**KIRKLEES METROPOLITAN COUNCIL
INVESTMENT & REGENERATION SERVICE**

DELEGATED DECISION TO DETERMINE PLANNING APPLICATIONS

Reference No:	2026/62/92292/W
Site Address:	Rydal Mount, Sheffield Road, New Mill, Holmfirth, HD9 7EX
Description:	Erection of dormer and external alterations
Recommending Officer:	Joshua Merriman

Officer Report – 2026/92292

Drawing number
RYM-STE-XX-ZZ-DR-A-20-002

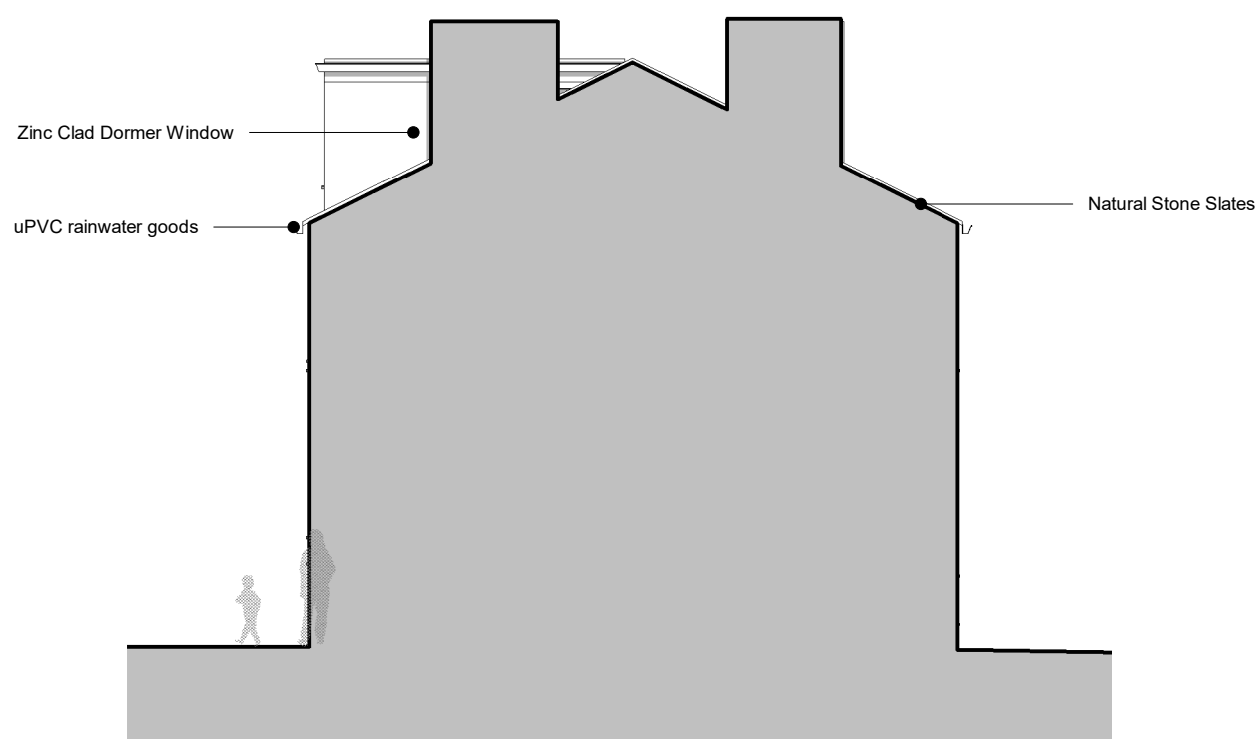
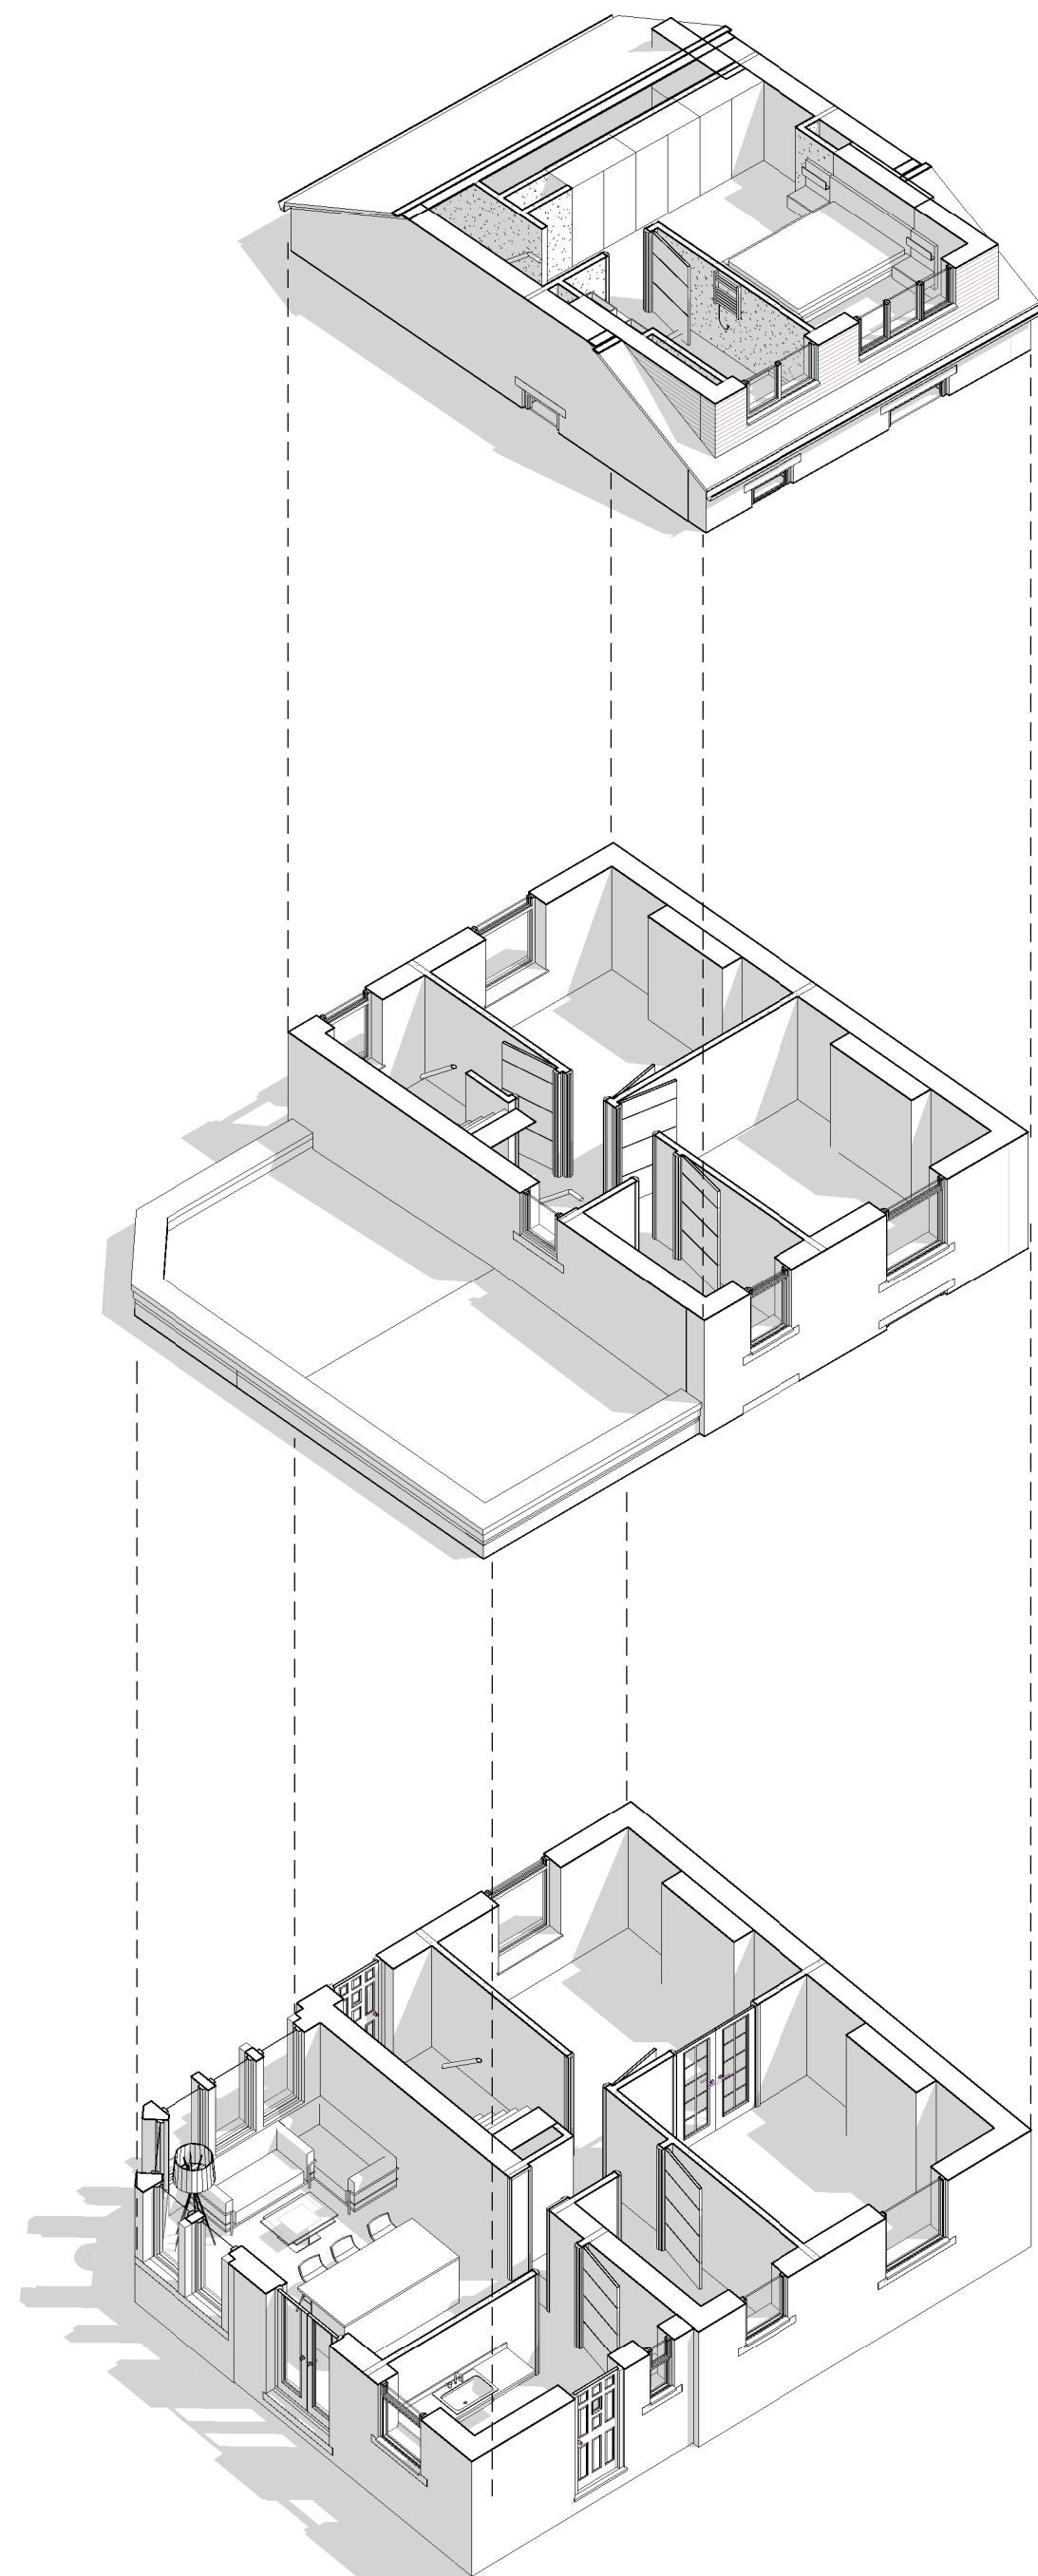
Concern was raised in regard to the overall scale and size of the dormer not complying with the House Extensions and alterations SPD. The agent stated that the dormers scale would benefit from PD fallback. The case officer granted weight to this argument.

The proposal involves the construction of a dormer window across the rear roof slope of the host dwelling. It is also noted that the property benefits from an existing single-storey side extension. Although the proposed dormer would be large in scale, extending across the full width of the rear roofscape, it is considered that, when viewed in the context of the existing two-storey dwelling, the roof extension would not result in a disproportionate increase in the size or scale of the original building. Accordingly, the proposal is considered to accord with Policy GB7(b) of the National Planning Policy Framework and Policy LP57 of the Kirklees Local Plan.

Although a GRP flat roof will be employed, as the dormer is located to the rear of the dwelling it is considered that this will not be largely visible from the street scene, and is therefore acceptable in this case. It is noted that the dormer window is proposed to be clad. In this instance the proposed fibre cement cladding to the walls of the dormer are considered acceptable given that the proposal will not have a significant impact on the visual amenity of the street scape and as there is an existing clad dormer along Sheffield Road, located close to the site.

The dormer will ensure a portion of the existing roof is to be retained at each side of the extension which is welcomed. Although the dormer is not set down from the ridge of the properties roof, as the extension benefits from permitted development fallback, these dimensions are considered acceptable, as a similar sized dormer could be erected without planning permission. Considering this, the design of the dormer is sympathetic and does not significant impact the visual amenity of the property or street scene.

2 Proposed Second Floorr GA Plan
1 : 100

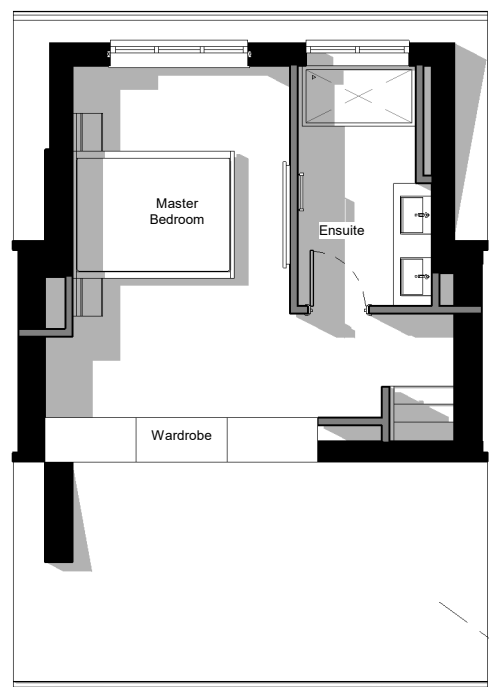
The number of bedrooms in the property will reduce from three to two as a result of the development, maintaining the off-street parking requirement from at two spaces. There is currently no off-street parking provision on the site, and the dwelling appears to benefit from a shared parking area to the North. Considering the number of off-street spaces will not increase, and the site currently has no off-street parking provision directly related, it is considered that the current arrangements are acceptable to remain.
